From: Nicola Spencer [REDACTED] on behalf of Planning
[REDACTED]
Sent: 14 January 2019 18:08
To: Sian Eggington
Subject: FW: FG/230/18/HH - 21 Clover Lane, Ferring
Attachments: 0016-001A Site and Location Plan.pdf
Categories: Orange Category

From: Craig Matthews [REDACTED]
Sent: 09 January 2019 15:58
To: Planning
Subject: FG/230/18/HH - 21 Clover Lane, Ferring

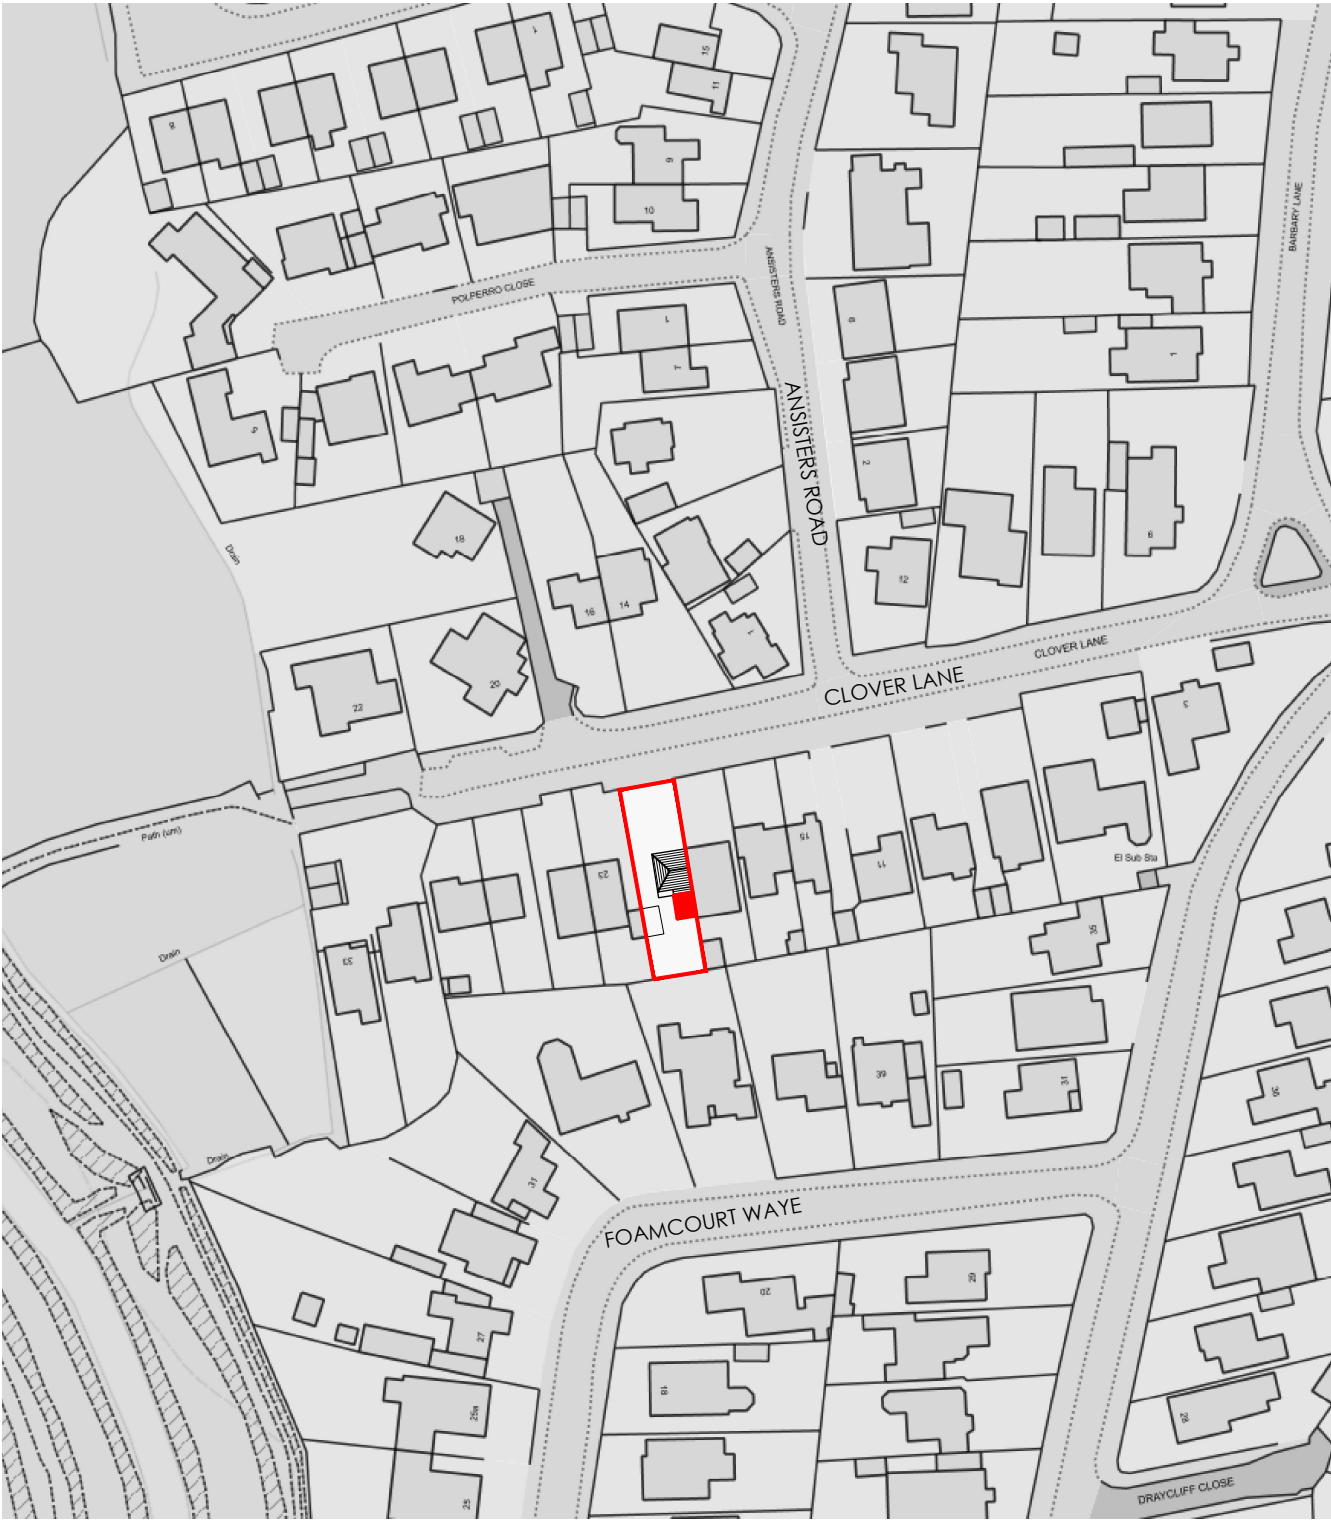
The Site/ Block plan was located in the drawing 0016-001 Site and Location Plan which has both the Location plan at 1:1250 scale and Block plan at 1:500. I have added measurements as requested.

Please find attached 0016-001A Site and Location Plan.
